**NORTH FALLS OFFSHORE WIND FARM DEVELOPMENT CONSENT ORDER**

**PINS REFERENCE EN010119**

**DEADLINE 7: COMMENTS ON  
THE EXA'S SCHEDULE OF CHANGES TO THE DDCO  
LONDON GATEWAY PORT LIMITED  
(IP REF: 20050576)**

Deep Water Route Cable Installation Areas (Future Dredging Depths) Plan

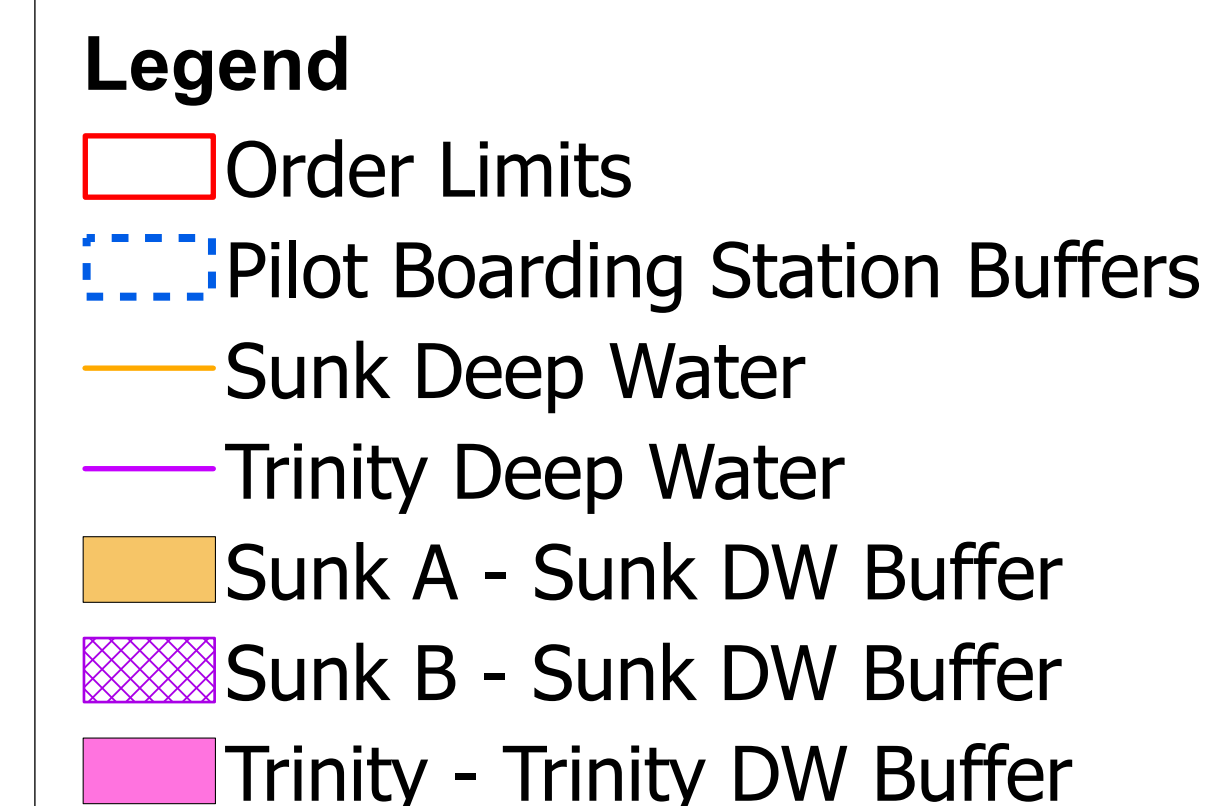
Article	ExA's Proposed Changes	LGPL Comment
<b>Schedule 2 Requirements</b>		
<b>Requirement 2(3)</b>	<p><del>"(3) Any part of Work No. 3 and any associated development the</del>  <b>authorised development</b> located within the following areas shown on the Deep Water Route Cable Installation Area (Future Dredging Depths) Plan, must be designed, installed, operated and maintained at a level which would not preclude or impede dredging:</p> <p>(a) of the area shown shaded in orange and labelled Sunk A – Sunk DW Buffer, to a level of 22 metres below Chart Datum;</p> <p>(b) of the area shown shaded in pink and labelled Trinity – Trinity DW Buffer, to a level of 22 metres below Chart Datum; and</p> <p>(c) to the area shown cross hatched purple and labelled Sunk B – Sunk DW Buffer, to a level of 19 metres below Chart Datum.</p> <p><b>(4) The undertaker must not carry out wet storage or relocate any boulders or archaeological finds to or within the three areas referred to in paragraph (3)."</b></p>	<p>LGPL supports these changes which were requested in <b>[REP5-097]</b> for the reasons set out there. The reference to wet storage in (4) is additional to LGPL's request but LGPL supports its inclusion further to the representations by the PLA. It would be contrary to the intention and purpose of the DWRs to permit wet storage there.</p>

<b>Schedule 9 – Part 1 (1)</b>	"Areas of Interest" means any part of those areas shown shaded orange, pink or hatched purple on the Deep Water Route Cable Installation Area (Future Dredging Depths) Plan;	LGPL agrees with the ExA's position. LGPL notes that this definition could also be used in other parts of the DML, but expects the Applicant will make the necessary changes accordingly.
<b>Schedule 9 – Part 2, Condition 10</b>	<p>New Requirement (as proposed to be amended for Schedule 2 Requirement 2 (3)) should be included in the DML Schedule 9 at condition 10 as sub-paragraphs (4) and (5).</p> <p><b>(4) Any part of the authorised development located within the following areas shown on the Deep Water Route Cable Installation Area (Future Dredging Depths) Plan, must be designed, installed, operated and maintained at a level which would not preclude or impede dredging:</b></p> <p><b>(a) of the area shown shaded in orange and labelled Sunk A – Sunk DW Buffer, to a level of 22 metres below Chart Datum;</b></p> <p><b>(b) of the area shown shaded in pink and labelled Trinity – Trinity DW Buffer, to a level of 22 metres below Chart Datum; and</b></p> <p><b>(c) to the area shown cross hatched purple and labelled Sunk B – Sunk DW Buffer, to a level of 19 metres below Chart Datum.</b></p> <p><b>(5) The undertaker must not carry out wet storage or relocate any boulders or archaeological finds to or within the three areas referred to in paragraph (4)."</b></p>	LGPL agrees with the ExA's position.

<b>Schedule 9 – Part 2, Condition 13 (3)</b>	"(3) In undertaking activities under paragraphs (2)(a), <b>(2)(d)</b> , (2)(e) and (2)(f), other than in areas shown shaded orange, pink or hatched purple on the Deep Water Route Cable Installation	LGPL agrees with the ExA's position

Area (Future Dredging Depths) Plan where navigable depth may not be reduced to any extent, the undertaker must not reduce water depth by more than 5% Chart Datum unless agreed with the MMO and the MCA in writing.”	
<b>Schedule 9 – Part 2, Condition 13(4),</b>	13 (4) An operations and maintenance plan substantially in accordance with the outline offshore operations and maintenance plan shall be submitted to the MMO for approval in consultation with the relevant SNCB, <b>the MCA and the PLA</b> at least six months prior to the commencement of operations. All operation and maintenance activities shall be carried out in accordance with the approved operations and maintenance plan and the approved cable specification and installation plan.	LGPL agrees with the ExA's position, however, LGPL suggests that the reference to “and the PLA” is changed to refer to “ <b>and the local harbour authorities</b> ” so that LGPL is also informed.

<p><b>Schedule 9 - Part 2,</b></p> <p><b>New Condition 36</b></p>	<p><b>Remediation</b></p> <p>(1) Where, following the installation or maintenance of cables forming Work No. 3, located within the following areas shown on the Deep Water Route Cable Installation Area (Future Dredging Depths) Plan</p>	<p>LGPL agrees with the ExA's position.</p>

<p>(a) the area shown shaded in orange and labelled Sunk A – Sunk DW Buffer;</p> <p>(b) the area shown shaded in pink and labelled Trinity – Trinity DW Buffer;</p> <p>(c) the area shown cross hatched purple and labelled Sunk B – Sunk DW Buffer;</p> <p>it is identified by the undertaker (who shall notify the MMO and the local harbour authorities as soon as reasonably practicable of this fact and in any event within 2 business days) or, following inspection by a local harbour authority (and the same is notified to the undertaker as soon as reasonably practicable), that the level of any cable is such that the condition 10(4) has not been achieved or at any time following installation or maintenance the cable has moved such that the requirements of condition 10(4) are no longer being achieved, then, unless otherwise agreed in writing with the MMO and the local harbour authorities, the undertaker is required to carry out remediation works as specified in the cable specification and installation plan subject to subject to sub paragraph (2) below.</p> <p>(2) Unless otherwise agreed in writing with the MMO and the local harbour authorities, the undertaker will carry out the following arrangements for the carrying out the remediation works:</p> <p>(a) the undertaker will re-bury the cable to the required specification to achieve the requirements of condition 10(4); and</p> <p>(b) following the completion of the works in sub-paragraph (2)(a), if it is identified by the undertaker or the local harbour authorities (following inspection) that the required specification is not</p>
